Response to Planning Application

From: Arun District Council Greenspace

Application ref: CM/48/21/RES

Description: Approval of reserved matters following the grant of CM/1/17/OUT for the erection of 300 No dwellings & a building within use class E, together with public open space, LAPs, LEAP & ancillary works, including car parking & drainage arrangements, with access off Church Lane & Horsemere Green Lane. This application may affect the setting of listed buildings & is in CIL Zone 4 (HSP2) & is not CIL Liable.

Revision N
Project Land at Climping Littlehampton
Title Site Plan
Dwg# 20.050.02
Status Planning

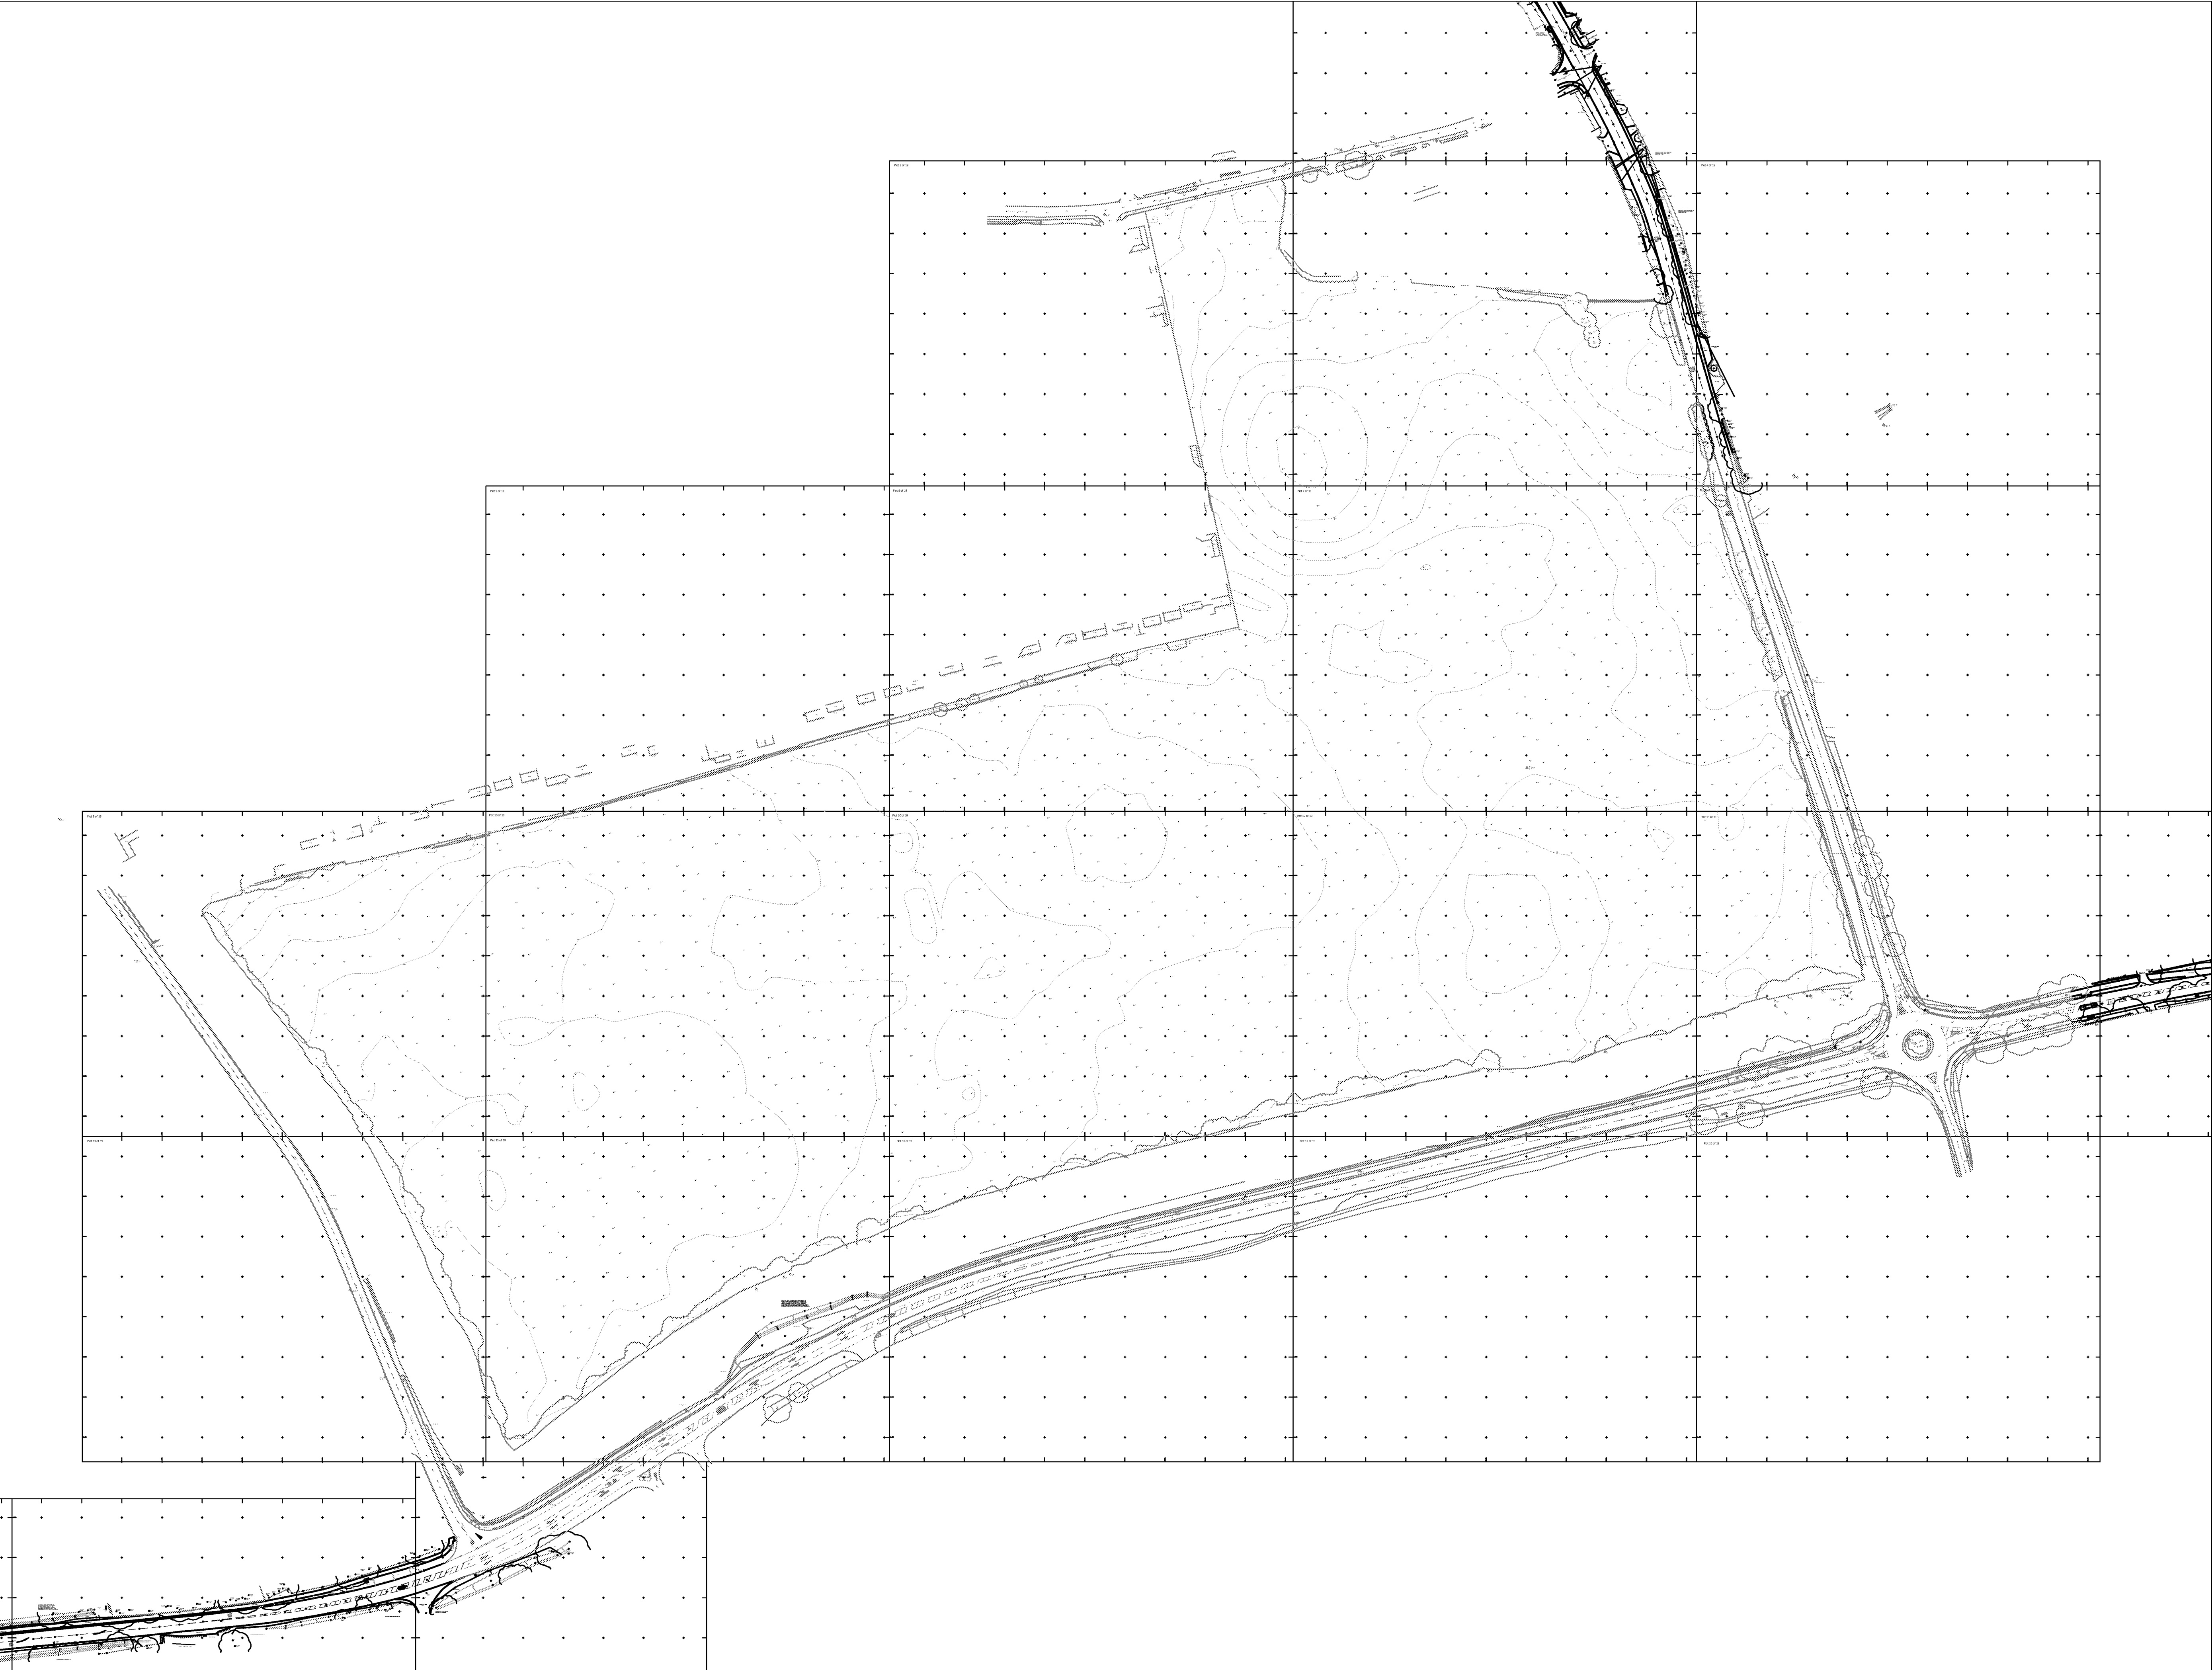
- The Site Plan 20.050.02.REVI has shown pathways within the site, these will need to be confirmed re surfacing and show a connected link within and beyond the site. The POS and play areas and primary pathways for pedestrian and cycleways throughout the site and across the POS areas to be DDA compliant and of Tarmac finish in order to allow year round access in these high trafficked access.
